**STATE SIGNIFICANT DEVELOPMENT:
Section 96(1A) Modification Application**

AUSTRALIAN TECHNOLOGY PARK, EVELEIGH

SSD 7317 MOD 3

Environmental Assessment Report
Section 96(1A) of the *Environmental Planning
and Assessment Act 1979*

1 URBAN FARM KITCHEN PLAN (4-05)
1 : 25

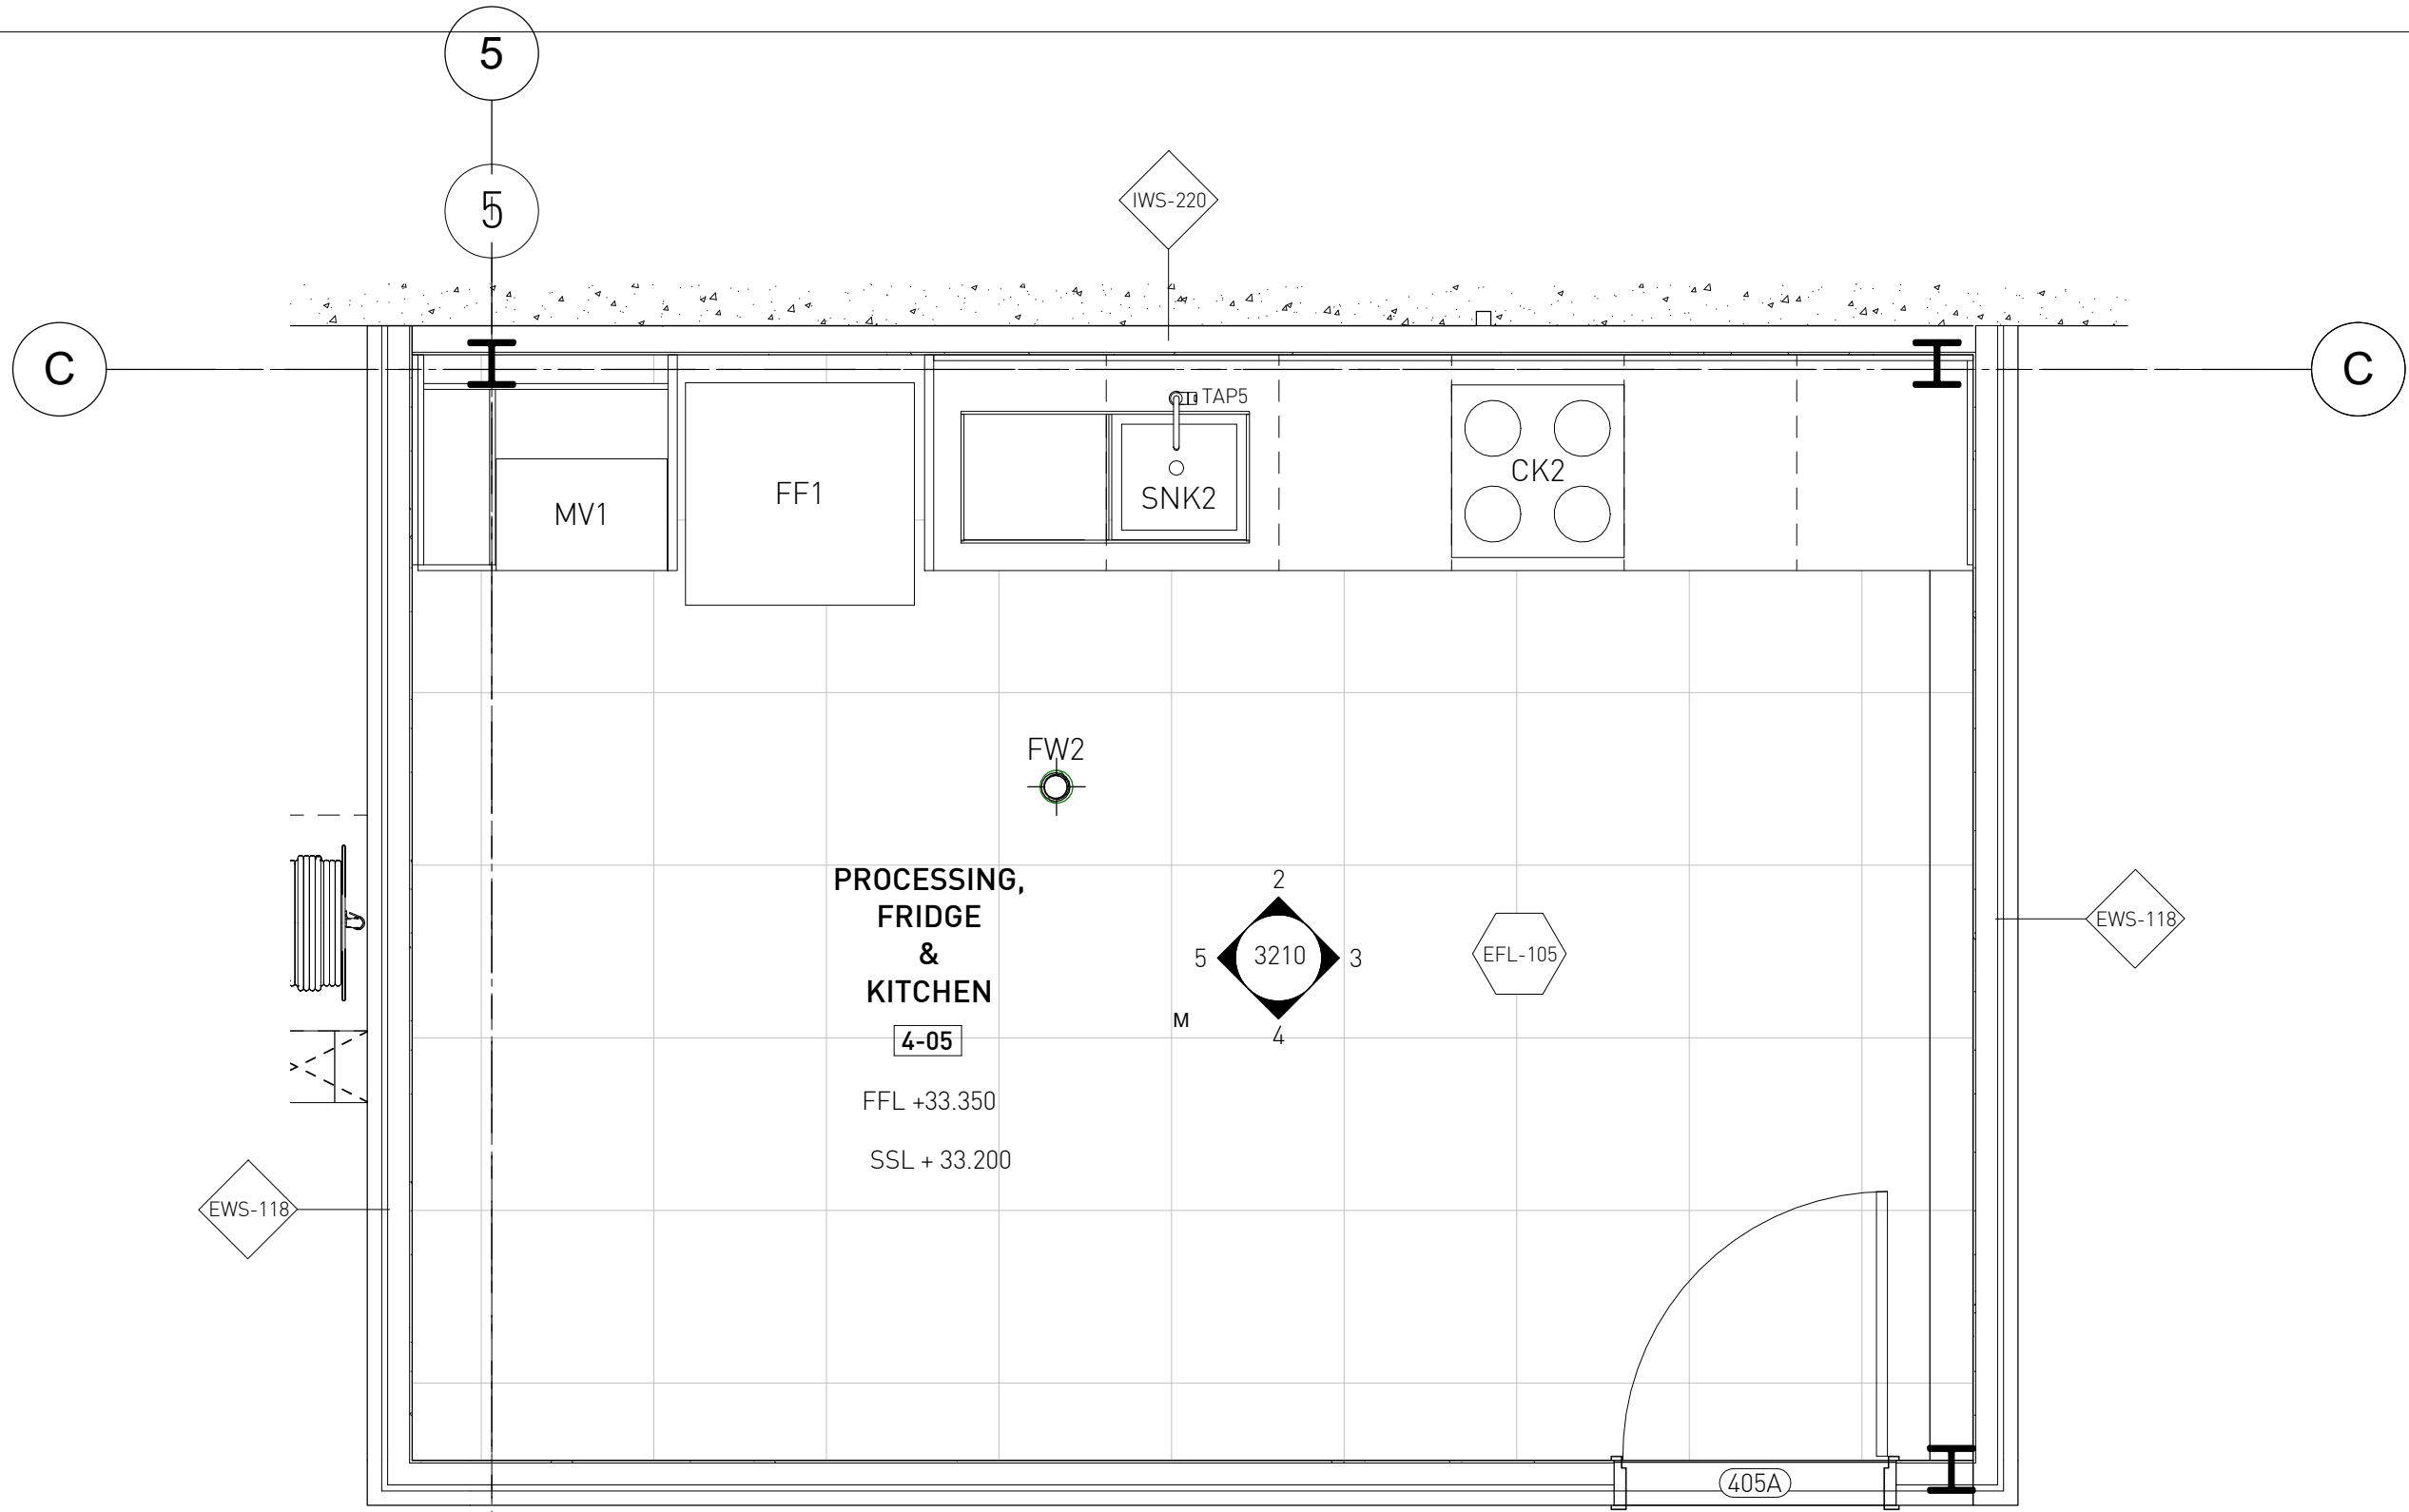
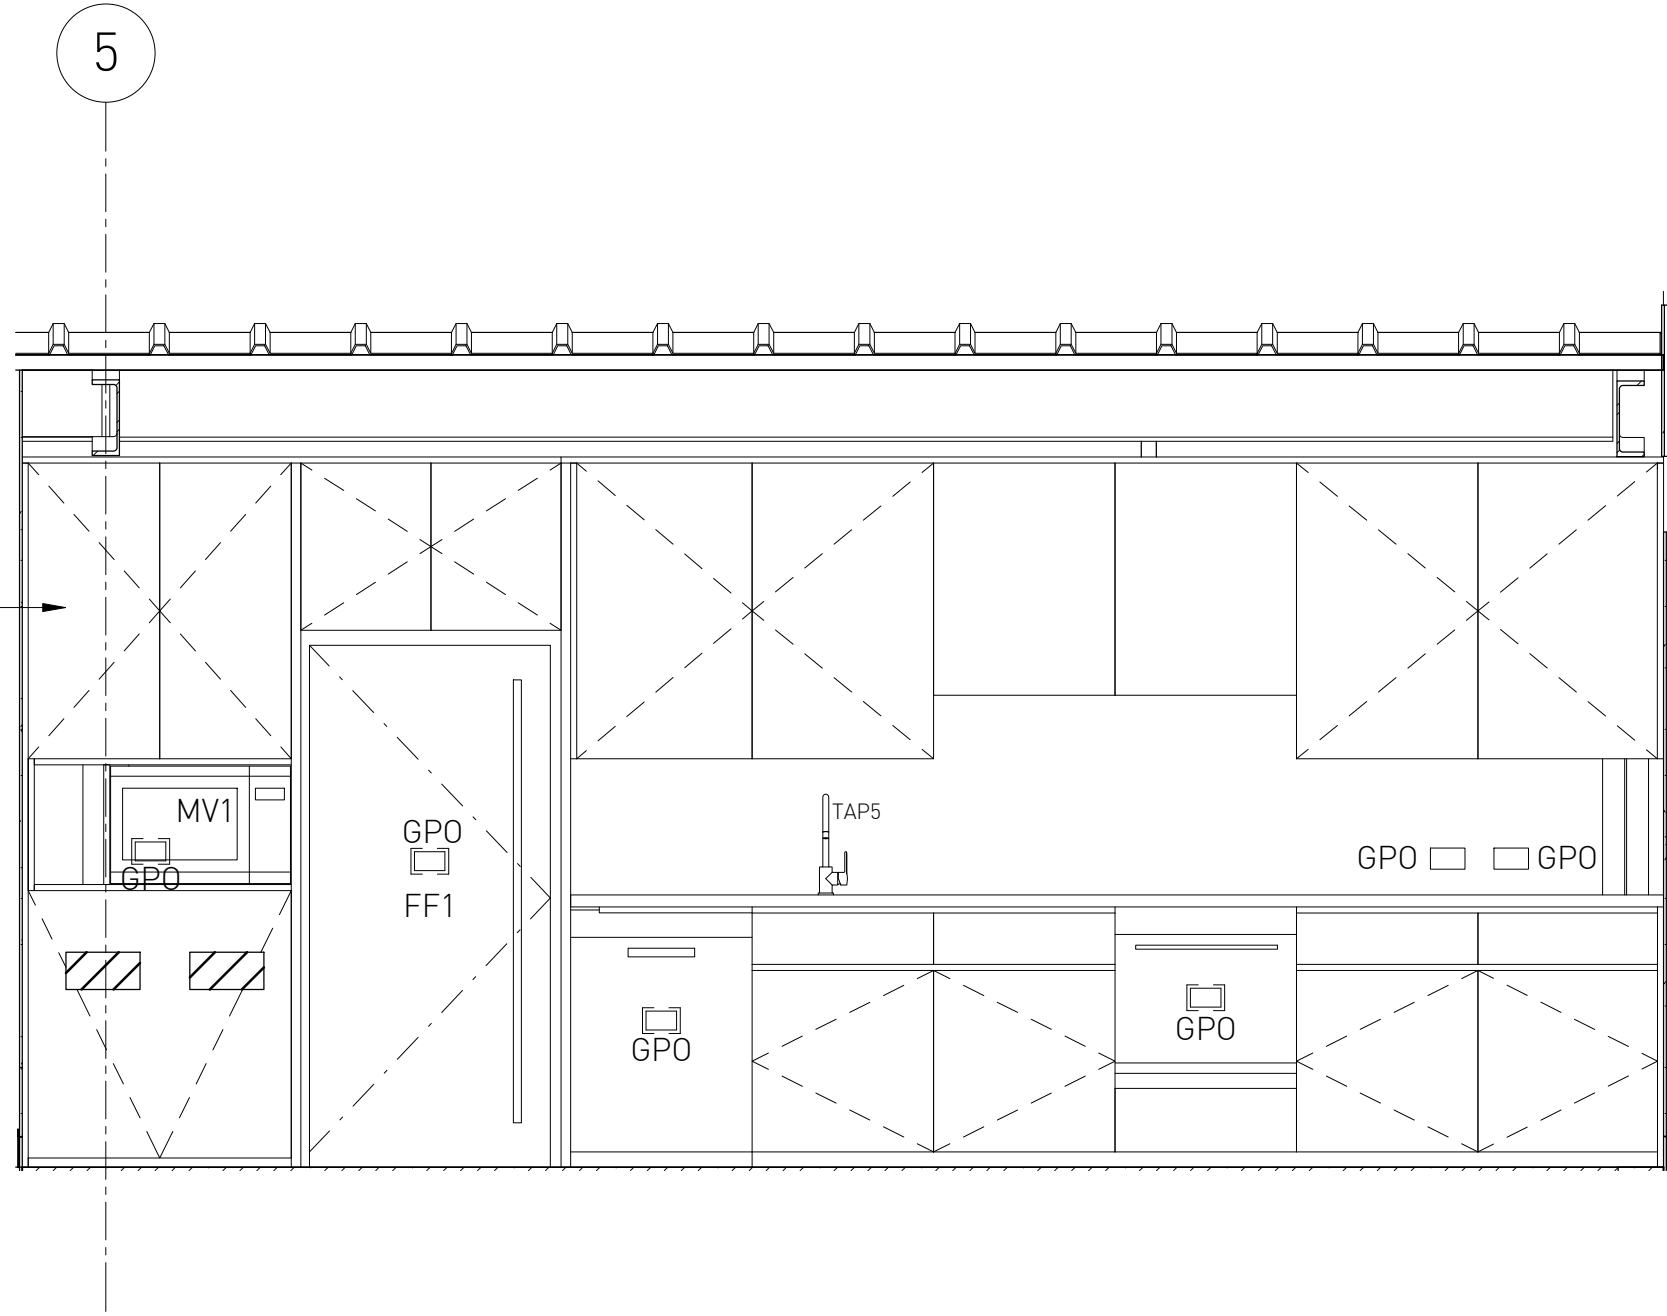
Council considers the community rooftop garden to be a positive addition to Building 3 but noted that insufficient information had been provided as to the design and operation of the space. As part of the RtS, the Applicant provided additional information including a draft plan of management (POM) for the community garden which covers the vision, type of planting, operating hours, access, funding and maintenance arrangements. Council has reviewed the draft POM and considers it to be acceptable.

The Department agrees that the rooftop community garden is a positive addition and believes it would contribute to the appeal of the building to the community, if appropriately managed. The Department recommends a detailed plan of management should be provided once greater detail on the future programming of the community garden is known. The detailed POM should address the matters covered in the draft POM in greater detail and will also need to address other aspects such as community access, community user groups, gardening practises, plot allocation, rostering, safety, waste and water management and mechanisms to encourage community participation.
